**Byers Gill Solar  
EN010139**

# 8.11 Environmental Statement (ES) Errata and Management Plans Proposed Updates

Deadline 5 – November 2024

Revision 3

Drawing Title  
**Figure 2.4  
General Arrangement Panel Area B**

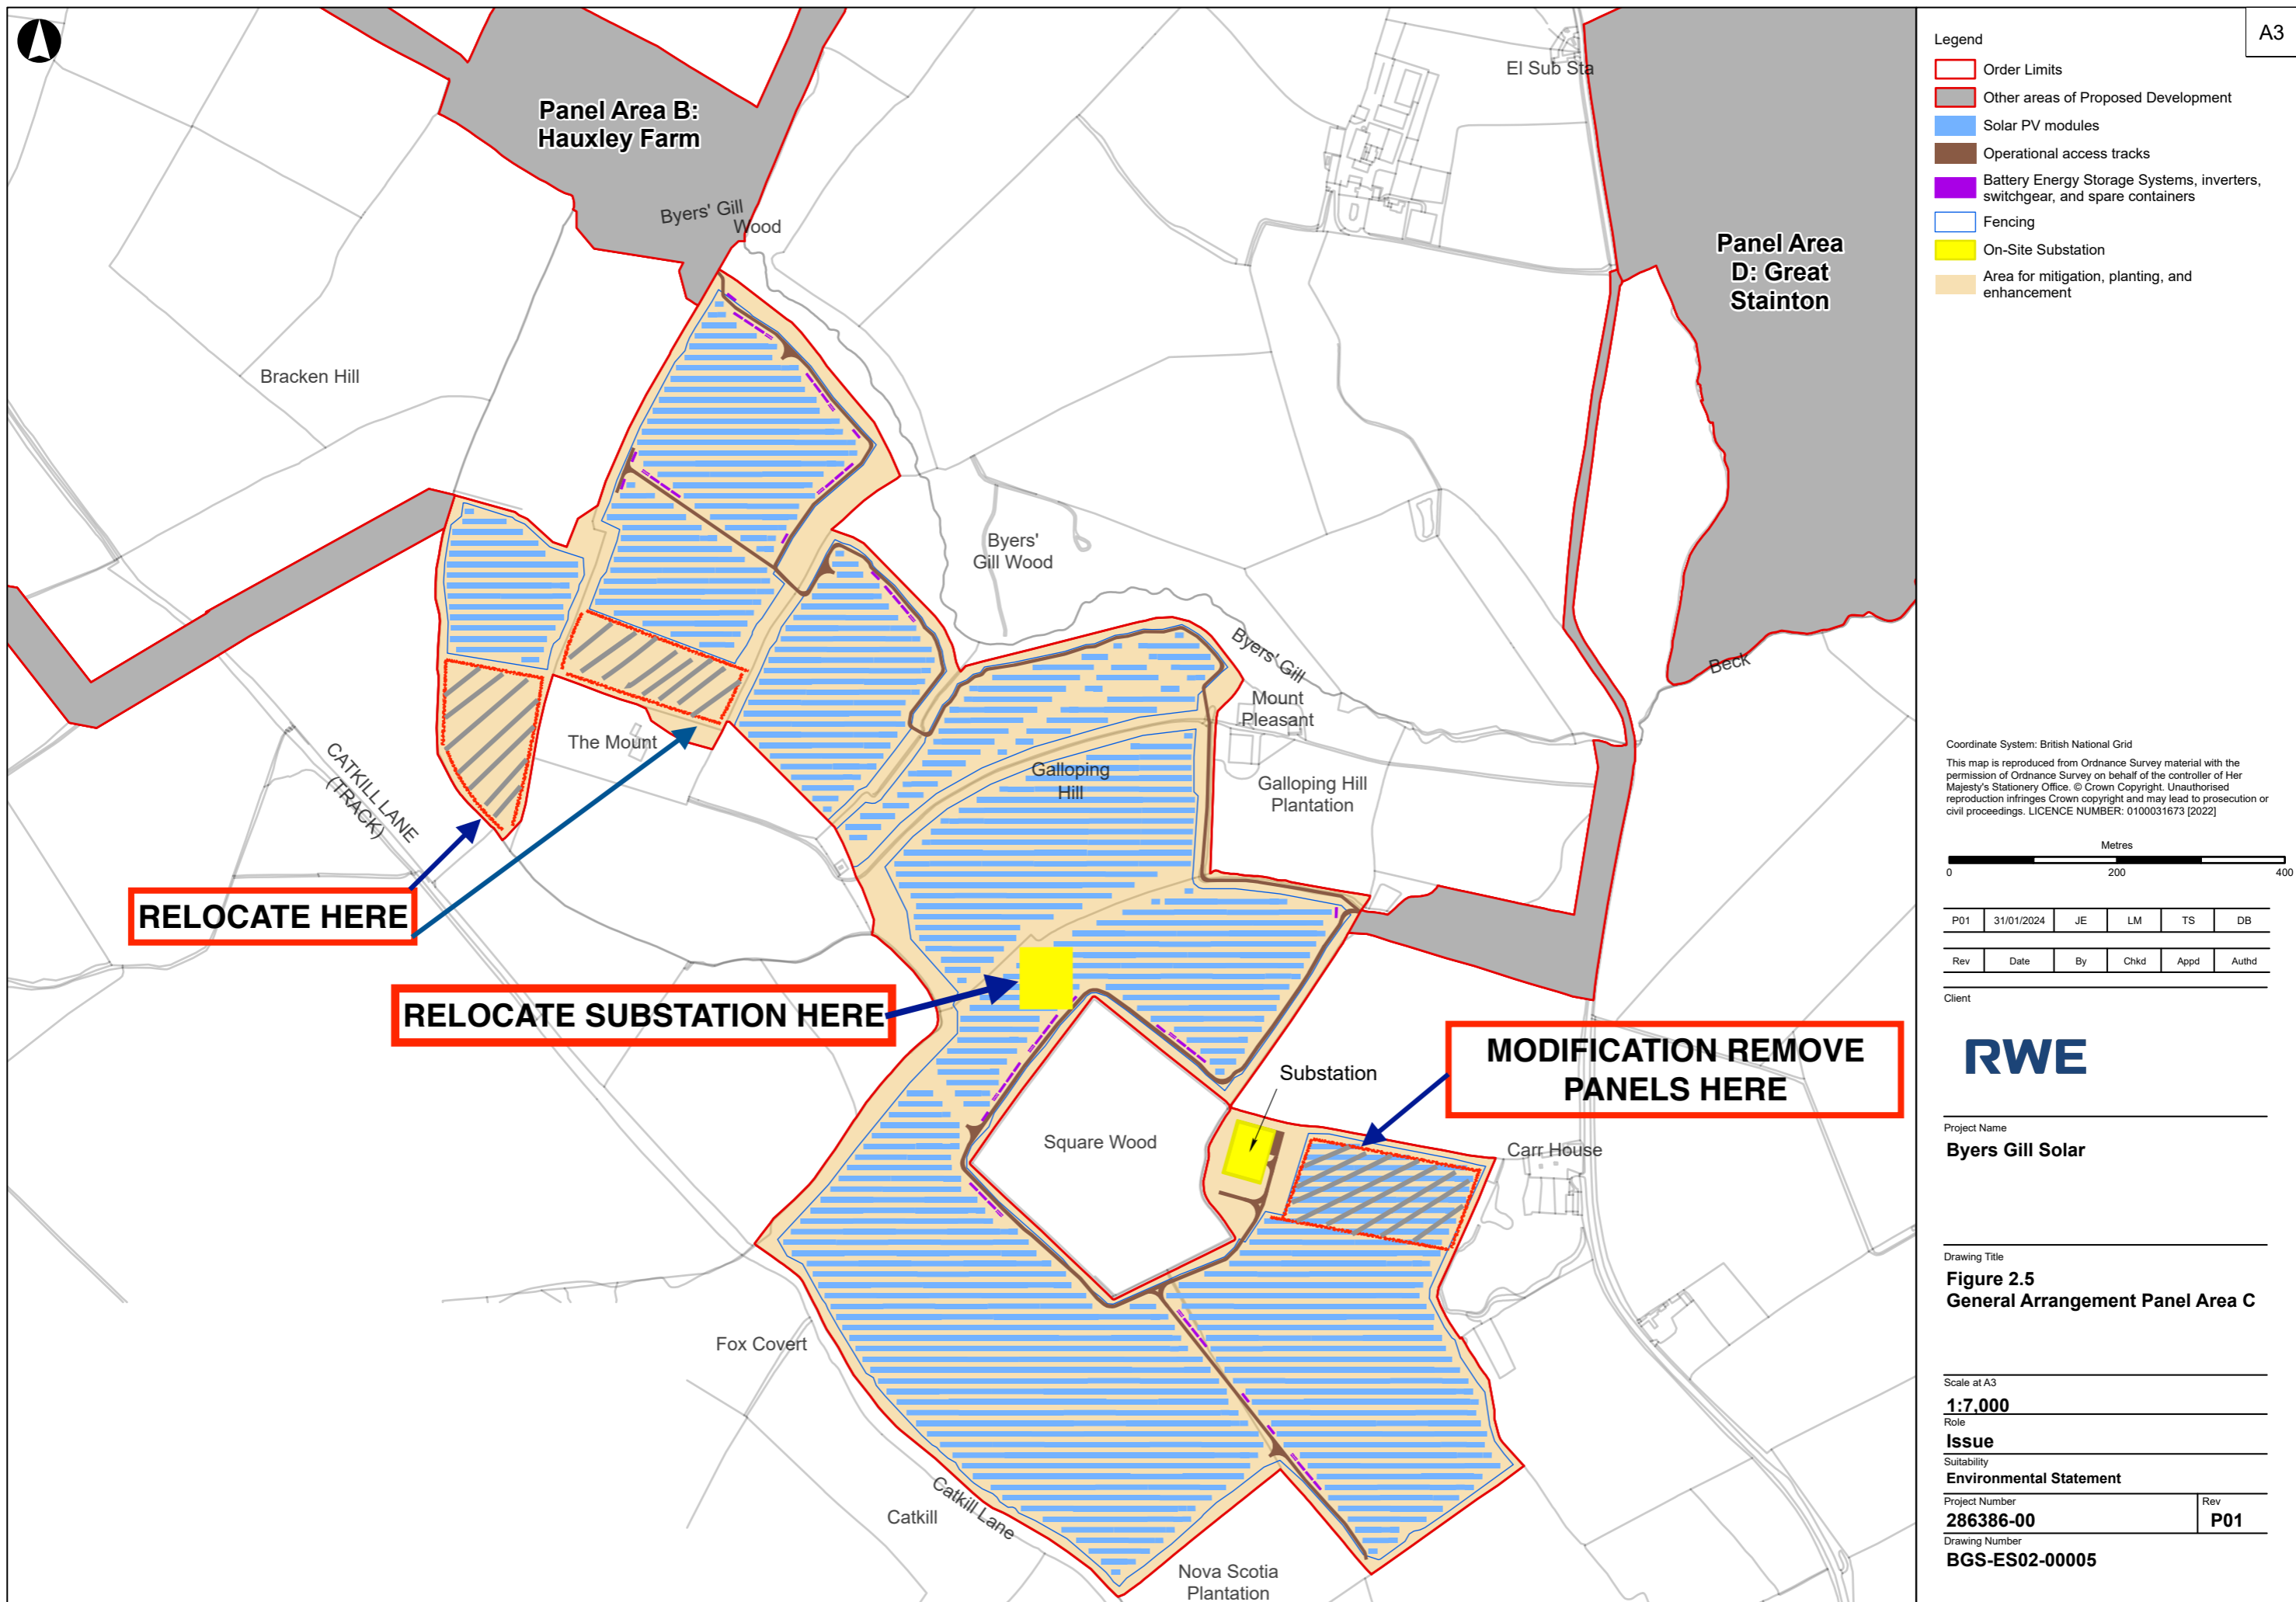
<ul style="list-style-type: none"> <li>ES Figures 2.3 – 2.8 General Arrangement Plans [APP-041 – APP-046]</li> </ul>	<ul style="list-style-type: none"> <li>In response to ExQ1 PPD 1.11 [PD-004]</li> </ul>	<ul style="list-style-type: none"> <li>Updated to provide proposed number of BESS and inverters on Legend for each panel area</li> <li>Order Limits updated to reflect the Bishopton Design Change made 9 July 2024</li> </ul>	Deadline 2	ES Figures 2.3 – 2.8 General Arrangement Plans [REP2-015 to REP2-021] submitted at Deadline 2
<b>Chapter 3 Alternatives and Design Iteration, associated Figures and other Appendices</b>
